# KITTTITAS COUNTY COMMUNITY DEVELOPMENT SERVICES

December 4, 2014

**RE: WDFW Hwy 10 Conditional Use & Shoreline Conditional Use Permits (CU-14-00006 & SD-14-00003)**

EXISTING SITE PLAN

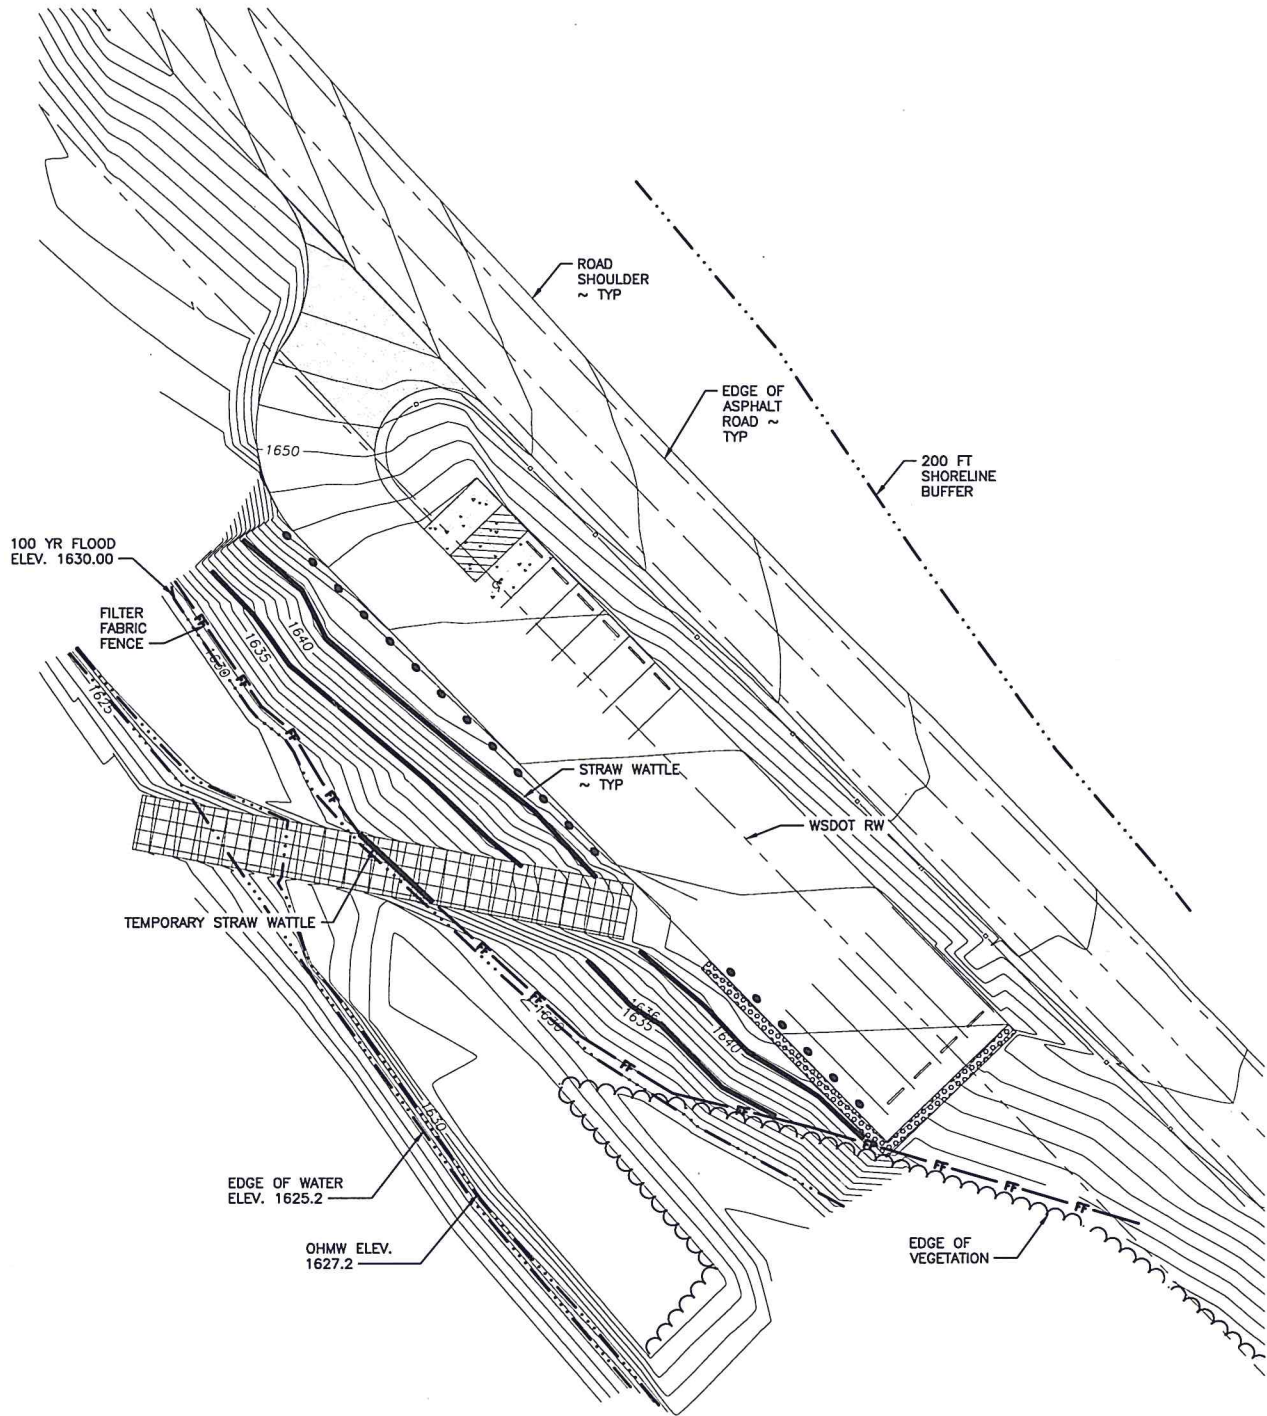
- a. *Revised site plan depicting :*
  1. *Ordinary High Water Mark (OHWM);*
  2. *Horizontal distances from OHWM to all "structures" on the property as defined by our Shoreline Master Program;*
    - a. *This includes horizontal distance from OHWM to vault toilet, ADA parking spaces, standard parking spaces, and trailer parking spaces;*
- b. *Response to Kittitas County Code (KCC) [Chapter 17.60A.015](#) Questions 1-7.*
- c. *Response to Kittitas County Shoreline Master Program, Section 36: Conditional Uses (2) (a-e). This can be found on our County website at the following address:*  
<http://www.co.kittitas.wa.us/uploads/documents/cds/smp/1975-Kittitas-County-SMP.pdf>
